From: Robert Findlay
Sent: 23 September 2008 09:48
To: Planning.Responses
Subject: FW: Planning Consultation on: LU/257/08/

APPLICATION NO: LU/257/08/

Registered: 08-SEP-08
Site Address: 26 High Street Littlehampton

Description of Works: Change of use from offices to ground floor restaurant and first and second floor flats.

Scale	1:50
Date	20th August 2008
Drawn by	
Drawing 5 / 5 Second Floor

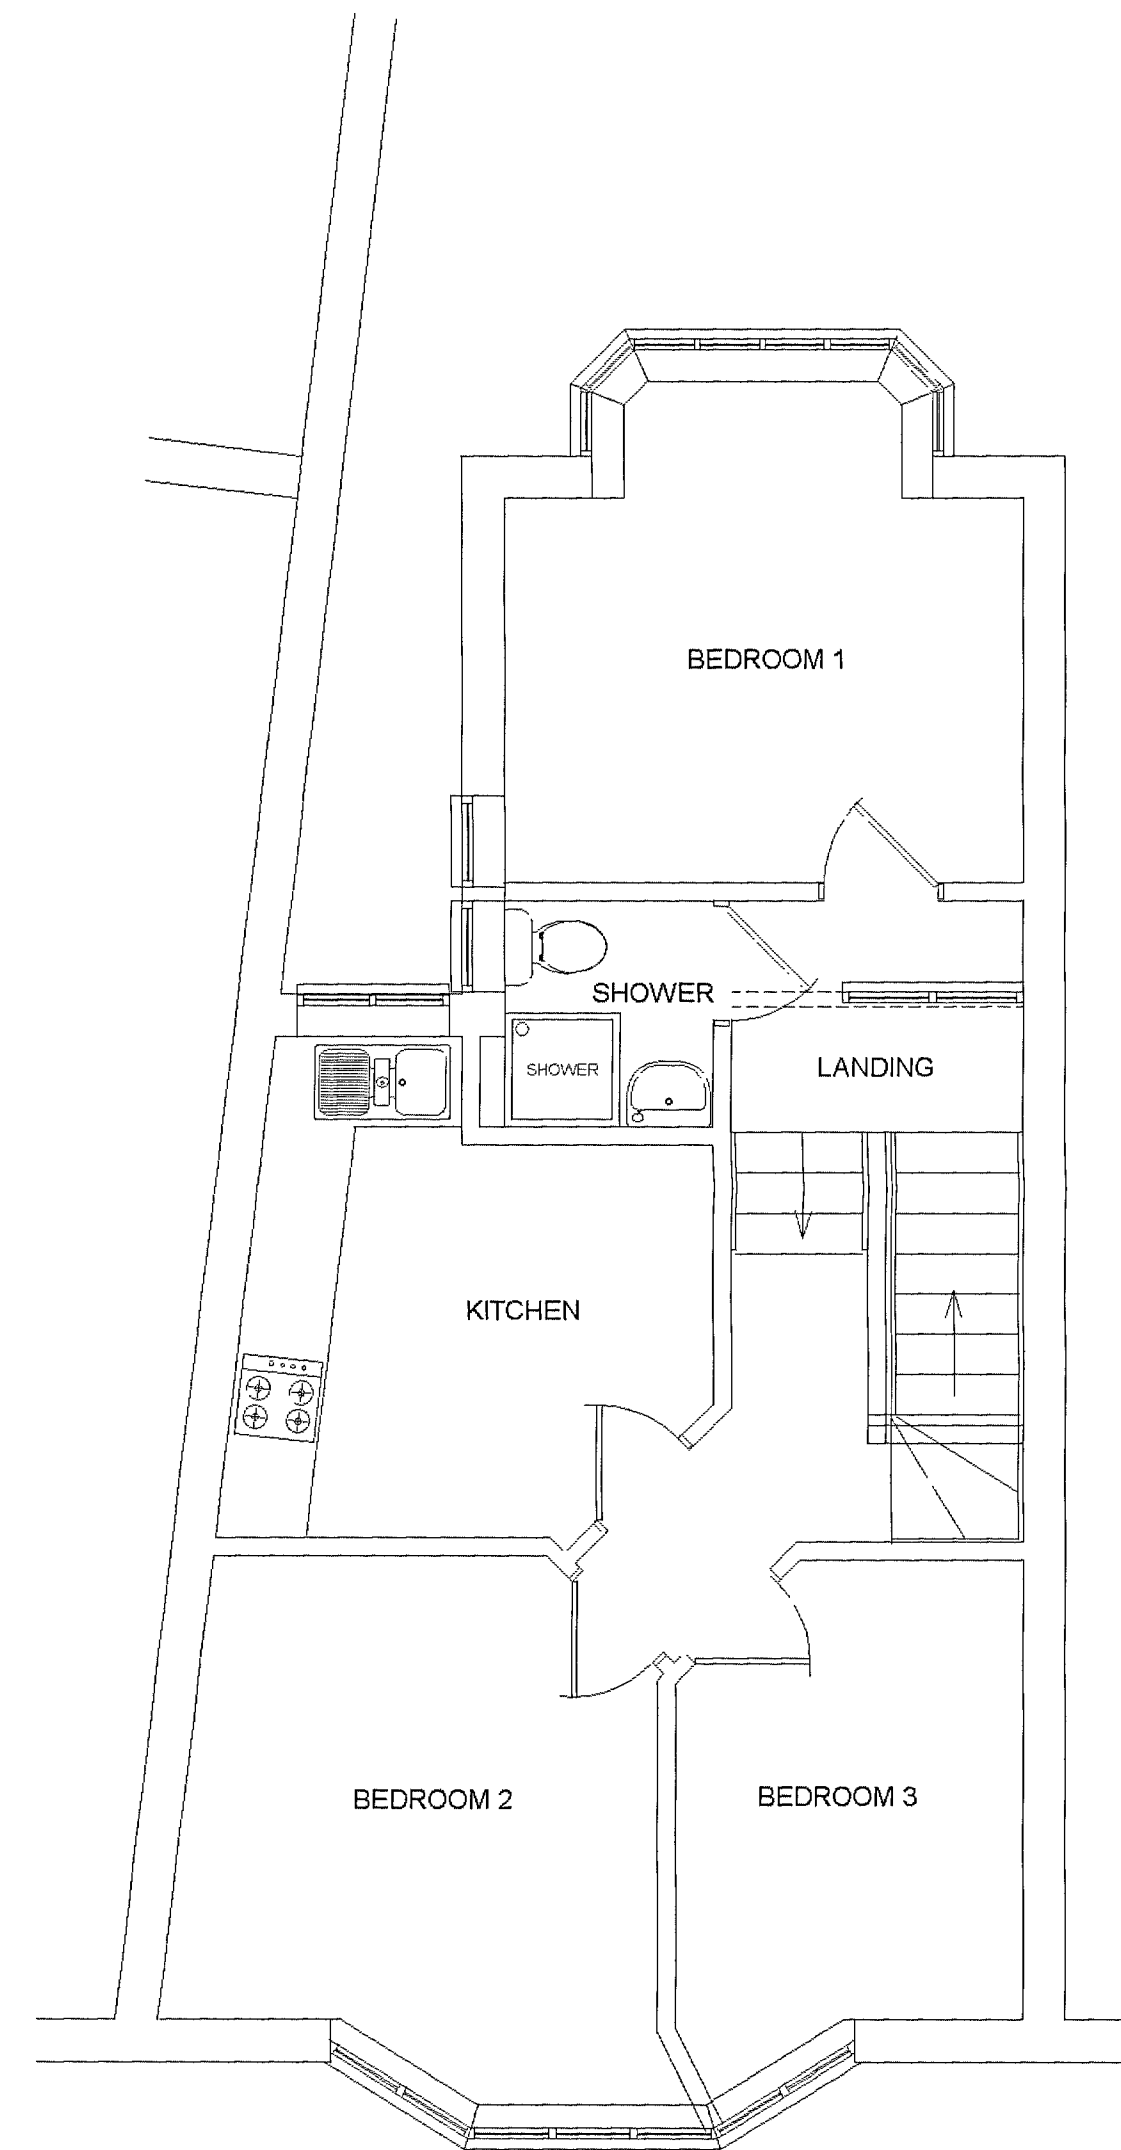
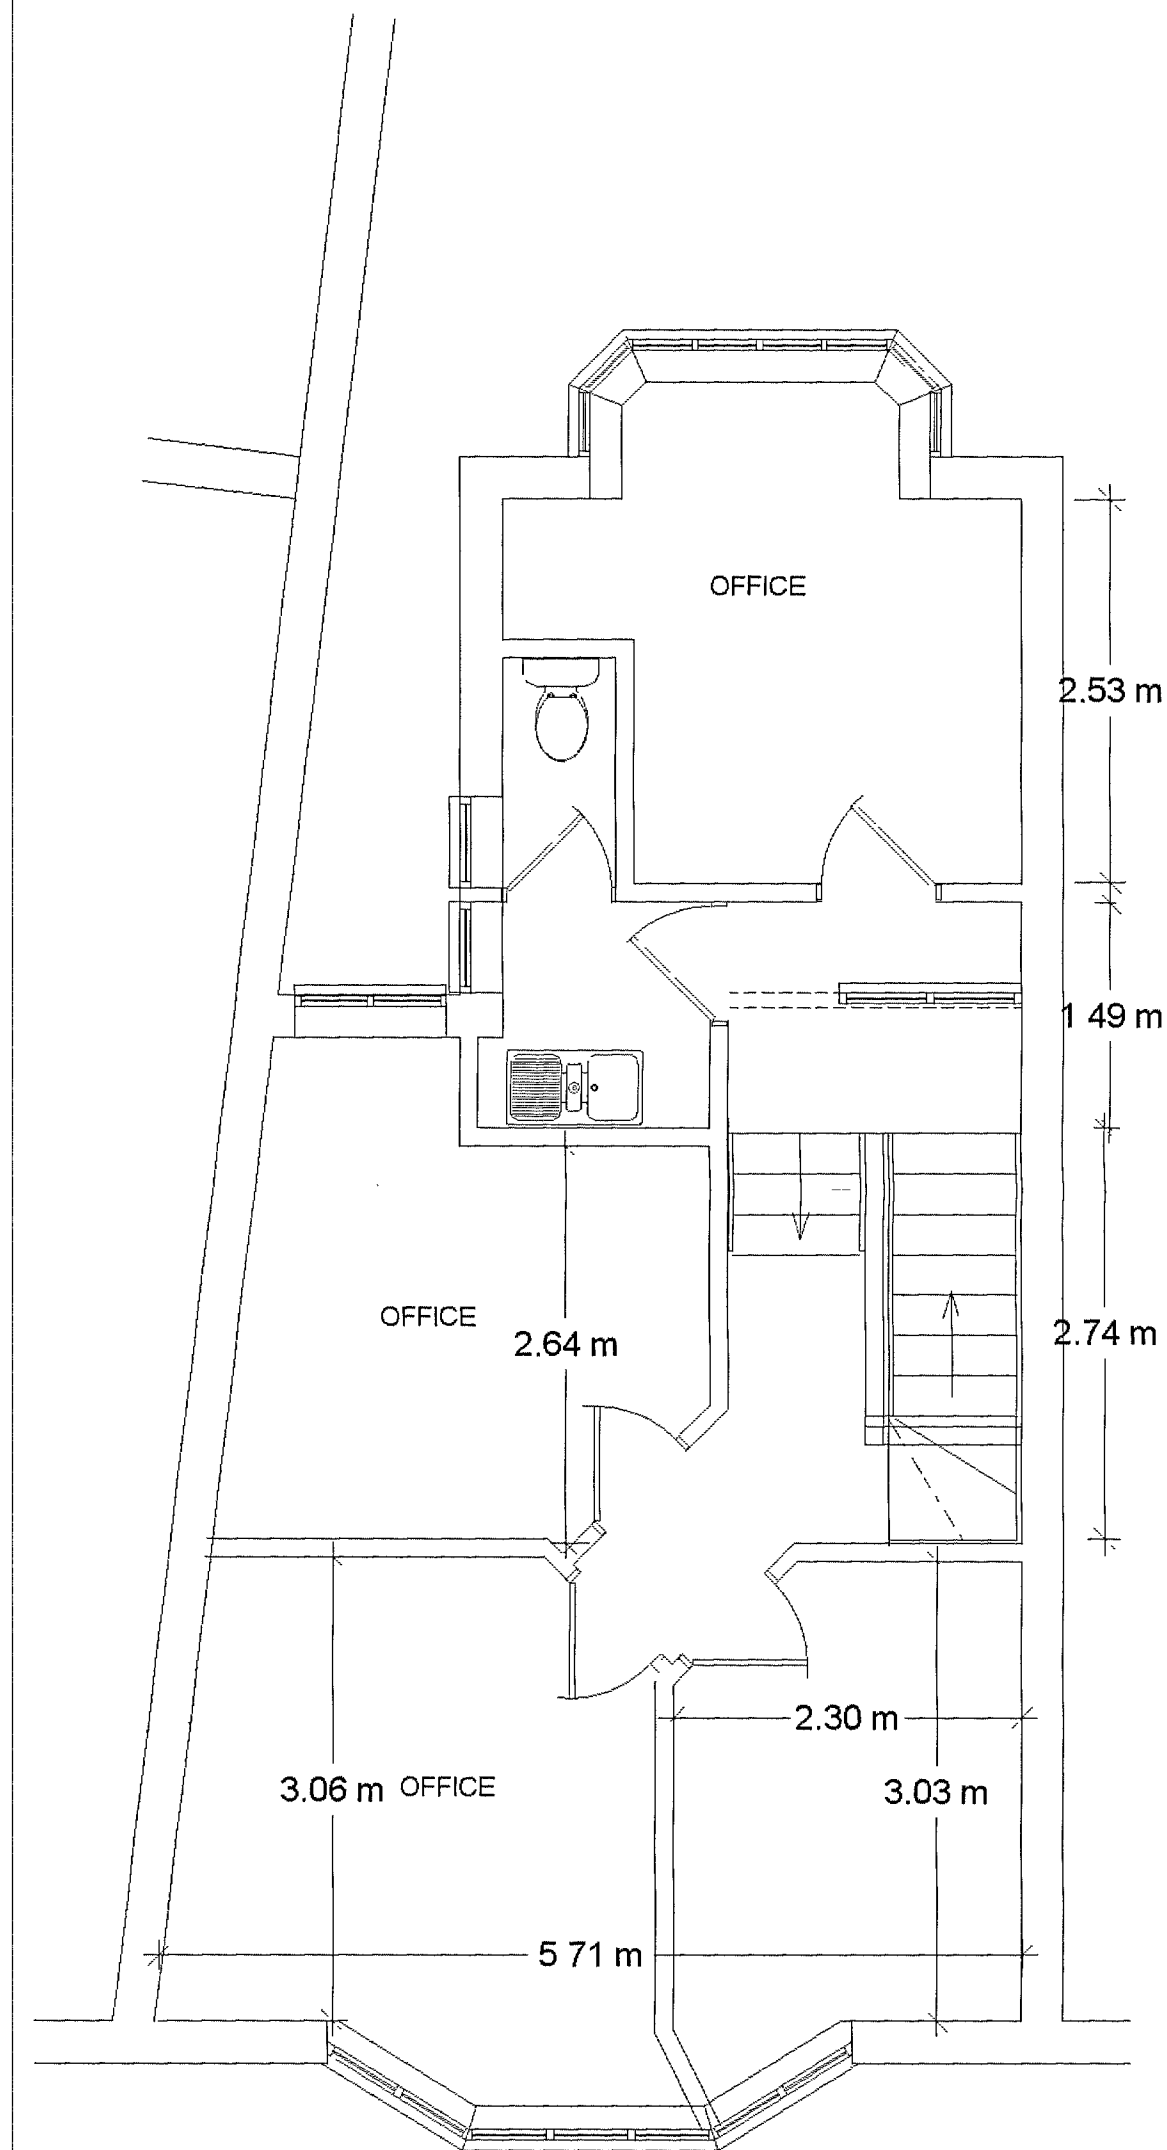
no objections in principle however the drawings supplied do not appear to convert to 2 flats as there are no living rooms shown only bedroom s this would indicate the property may be creating a house in Multiple occupation that would be of a prescribed description that would necessitate licensing it is advised the owner/developer contact Env Hlth to discuss
